From: [Karen Hodges](#)
To: [Jeremy Johnston](#)
Subject: RE: request for floodplain review
Date: Wednesday, May 23, 2018 8:30:18 AM

I received two shoreline exemption applications from Grant PUD. Everything appears kosher on the land use side, but I thought I should give you an opportunity to take a look at them for floodplain review. One is for an informational Kiosk at the Ellensburg Boat Club Launch and the other is for fence posts (serving as boundary delineation signs) at the Vantage Boat Launch. I have attached both master files. My hope is to issue these early next week if you do not see any issues. Thanks.

Site Plan

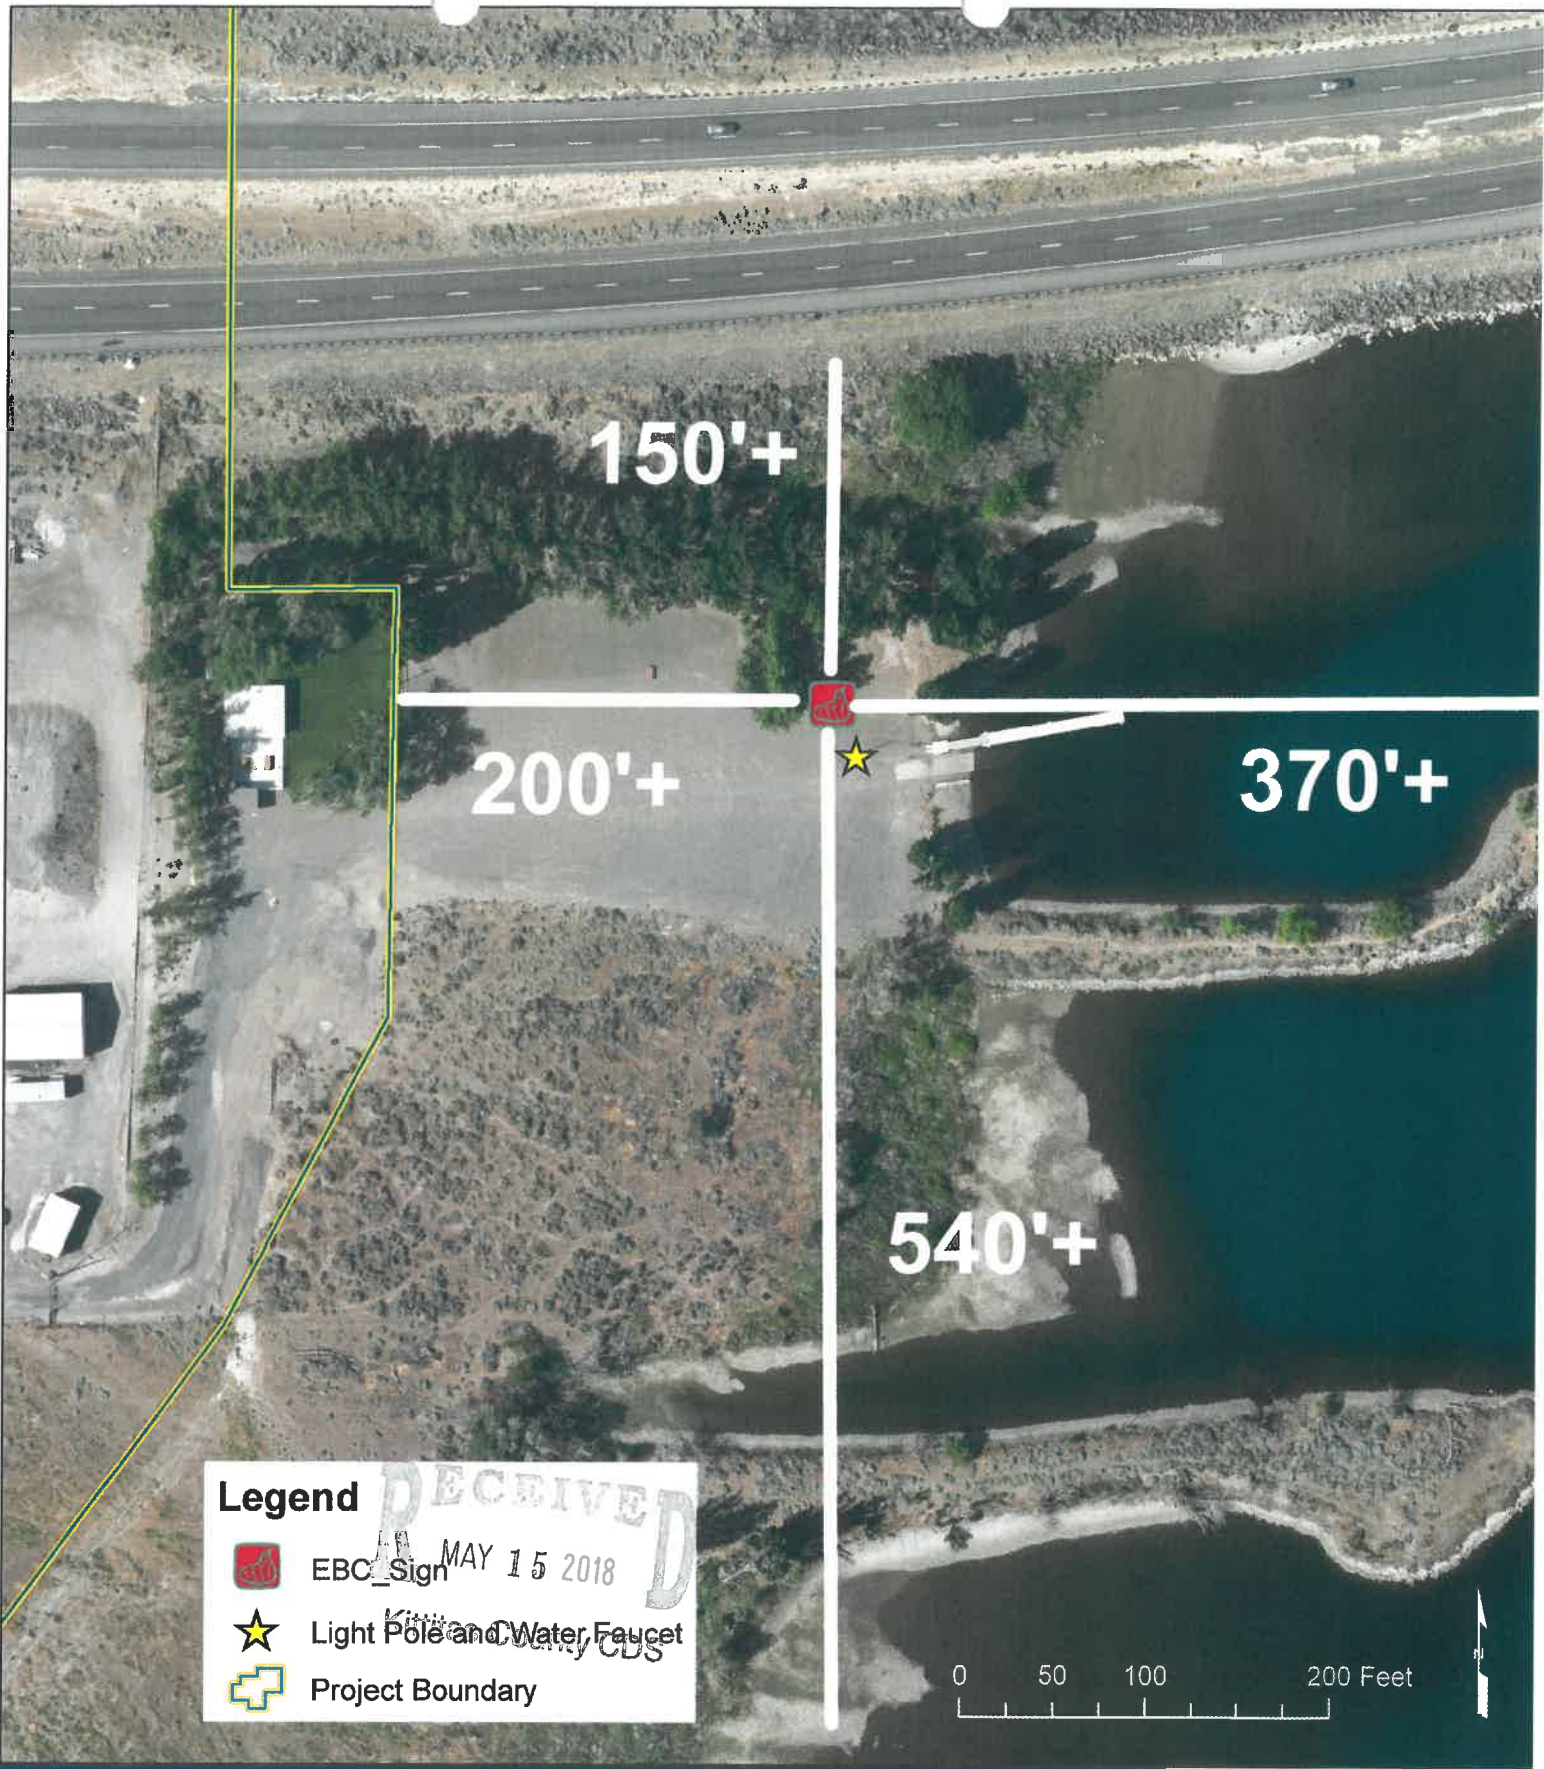
However, I want to ensure that when they do build the fence in the next phase; they will use something with openings...not a solid fence.
